William Simcock
Kirklees Metropolitan Borough Council
Development Management

Our ref: RA/2024/147770/05-L01
Your ref: 2024/91476

ERECTION OF 24 DWELLINGS – CLOUGH FARM, LONG LANE, EARLSHEATON, DEWSBURY, WF12 8LQ

Thank you for re-consulting us on this application following submission of additional ecology information / amended plans, which we received on 4 April 2025.

APPENDIX 2: Proposed Landscaping

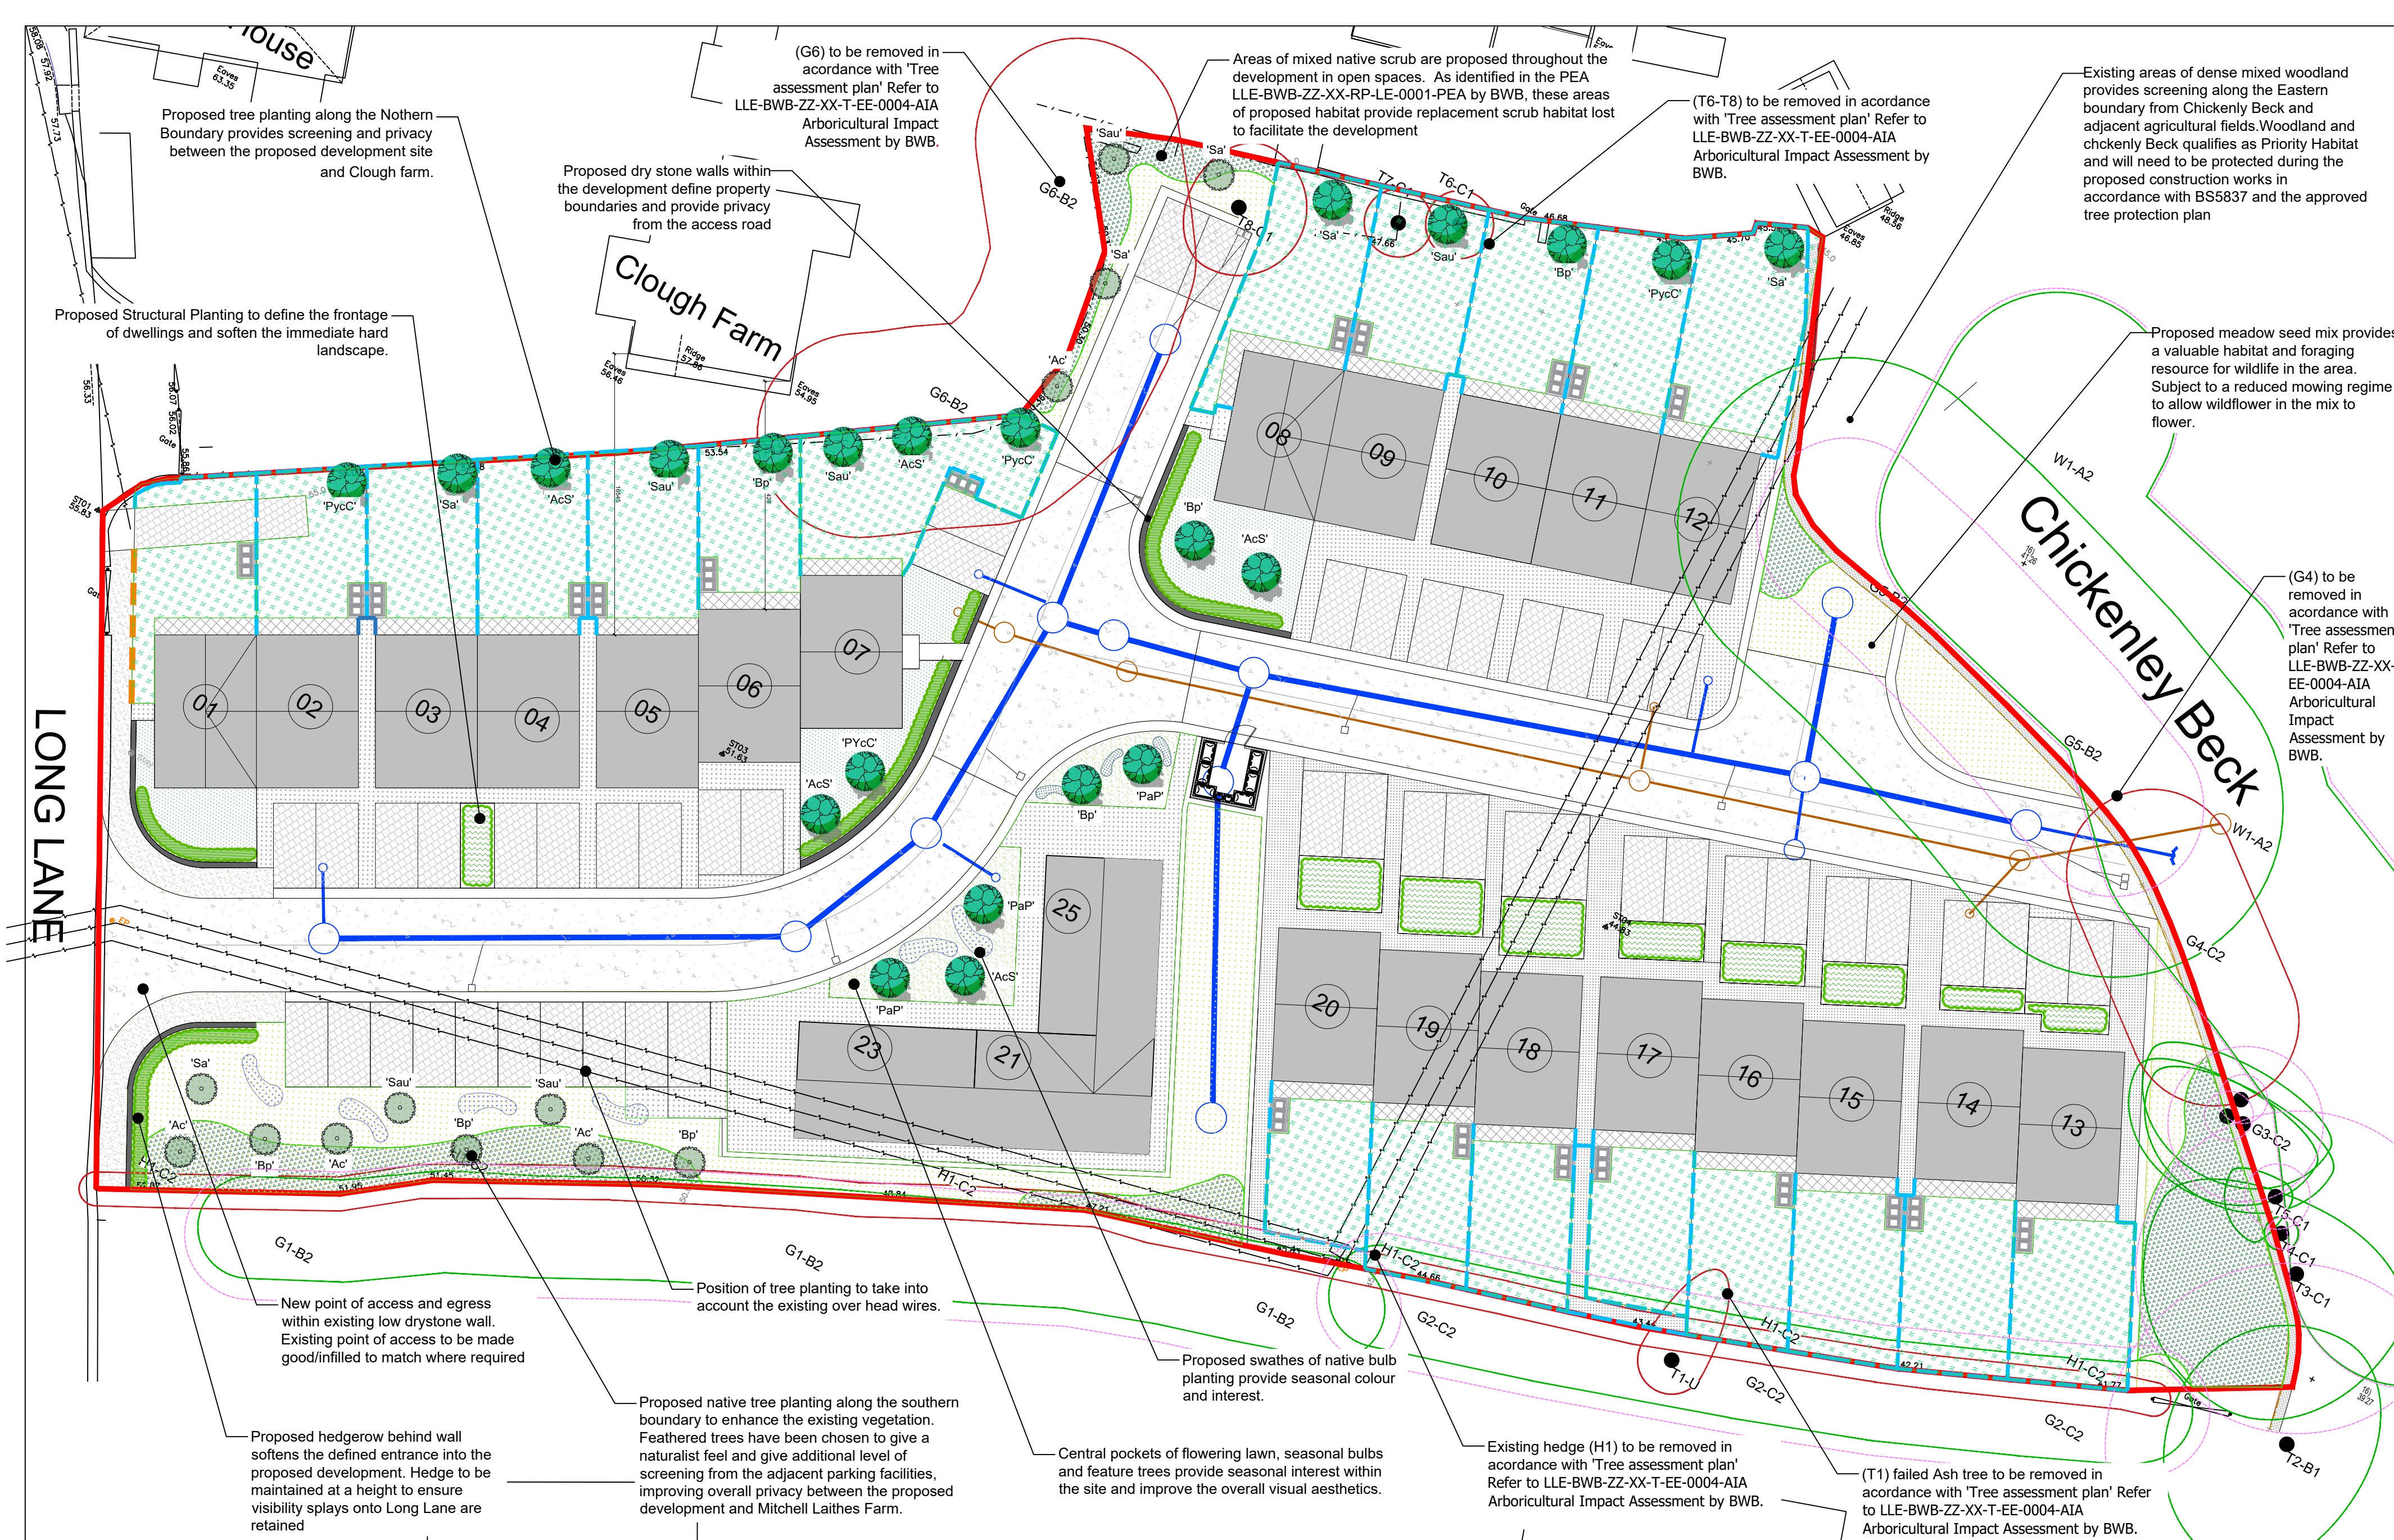
As the development includes building housing, parking spaces and a road in the riparian zone, the post development riparian encroachment will be higher than the baseline riparian encroachment as the riparian zone is currently undeveloped.

The applicant has now provided a landscape plan which shows the retention of existing trees and vegetation along the river corridor, as well as providing an updated BNG statement which recognises the Watercourse Units on site and accounts for delivery of 10% uplift (dependent on revision to the post-development encroachment values provided in the metric, see informative above). As a result, the risk to the riparian zone is better known and we therefore accept that a WFD Assessment for the development is no longer necessary.
